Planning Statement

Removal/Variation of a Condition to planning permission: **PL/2023/00294/MINFHO**.

This application site is situated at 82 Coverdale Road, Solihull, B92 7NT.

‘Wraparound extension with two storey rear extension’.

Drawing Title:  
Proposed Floor Plans

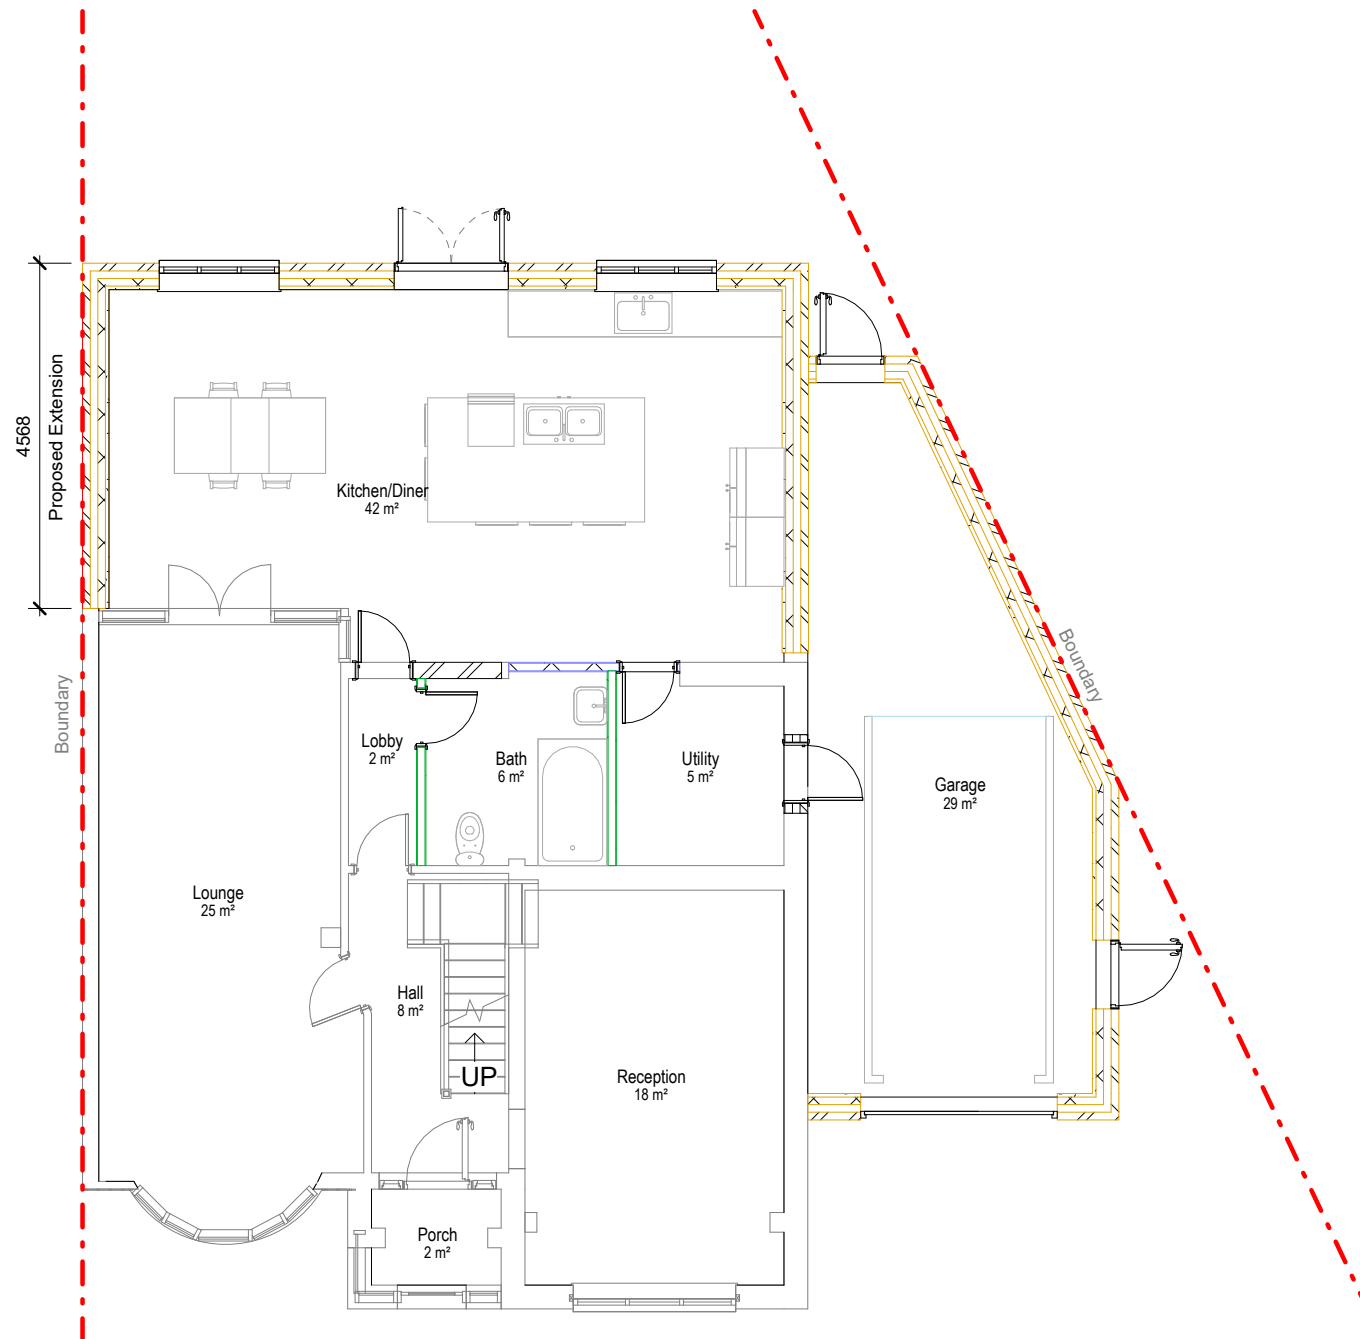
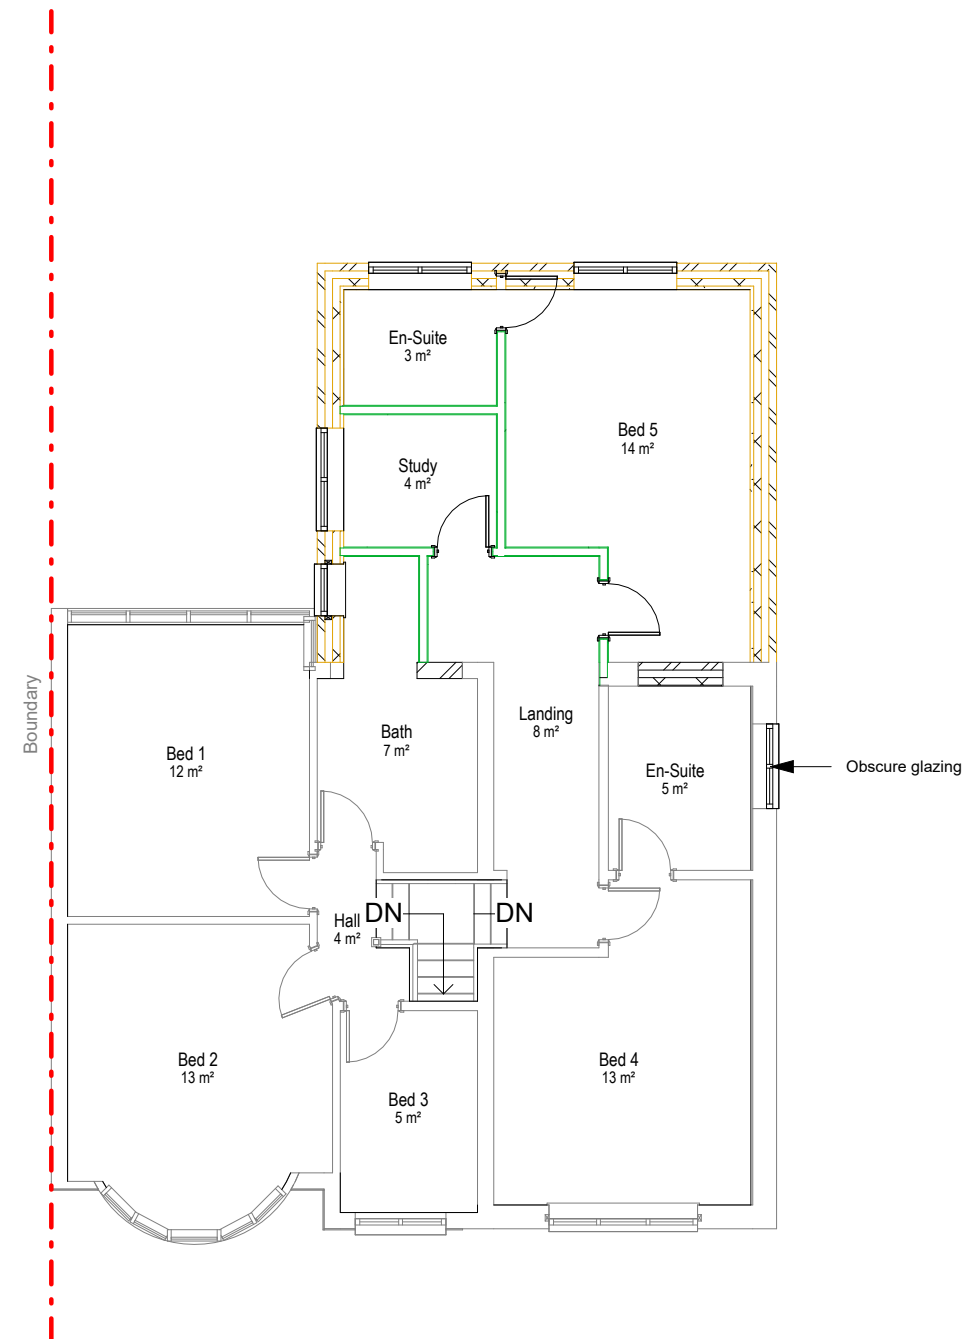
We intend to make an amendment to the current approved drawings as we feel it would be beneficial to the property. We intend on increasing the width of the double storey rear extension as this will cater for a new en-suite, study room and extend the existing bathroom on first floor.

We will not be cutting any neighbours’ right to light (45-degree rule) and will not be oversizing the new proposed extension as it is only increasing by approximately 2m in width.
